SOUTHEASTERN SOIL & ENVIRONMENTAL

Regarding: LOT 60, FOREST OAKS (3 pages)

I HAVE LAID OUT A SYSTEM ON LOT 60

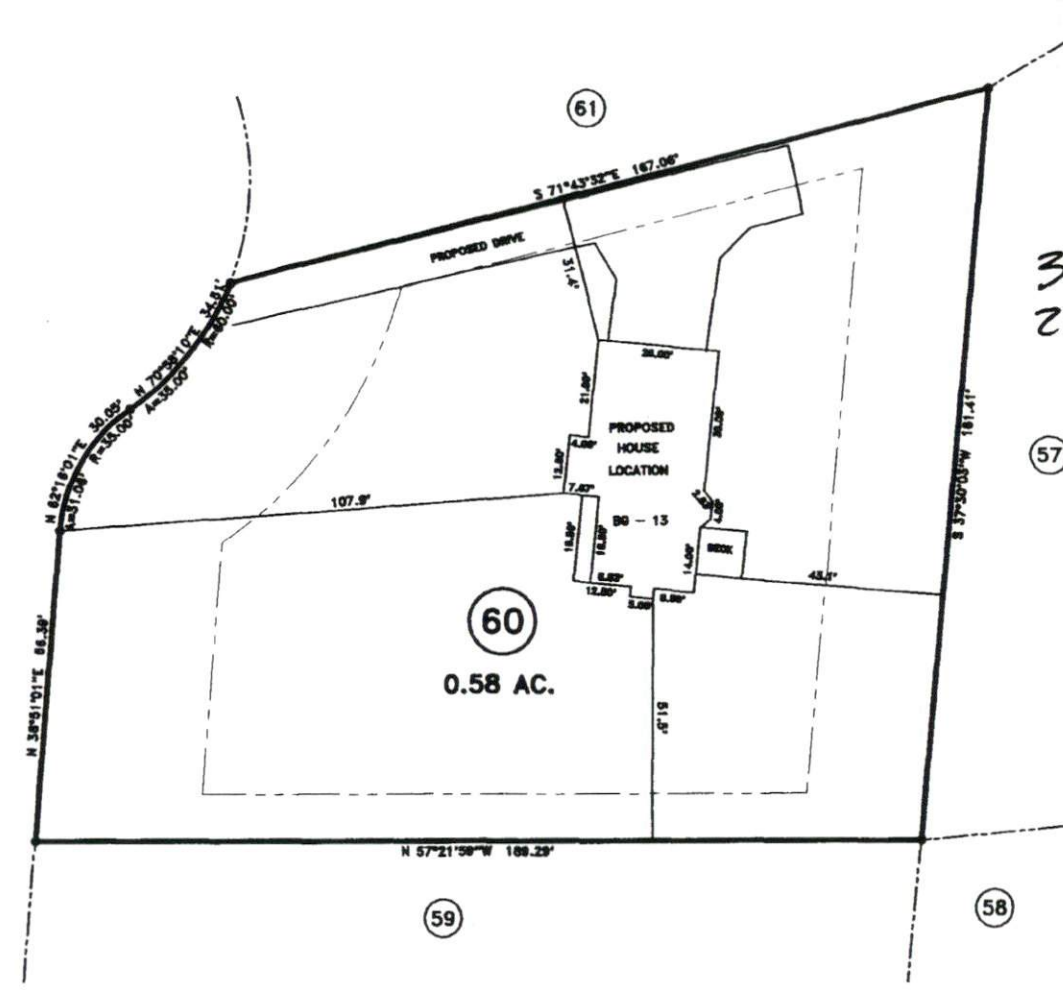
FOREST OAKS USING YOUR PERMIT REQUIREMENTS

I BELIEVE THEY CAN HAVE A FRONT LOAD

GARAGE STARTING AT LEFT PROPERTY LINE CORNER

AND ANGLING TOWARD HOUSE.

PLEASE REVIEW AND ADVISE.
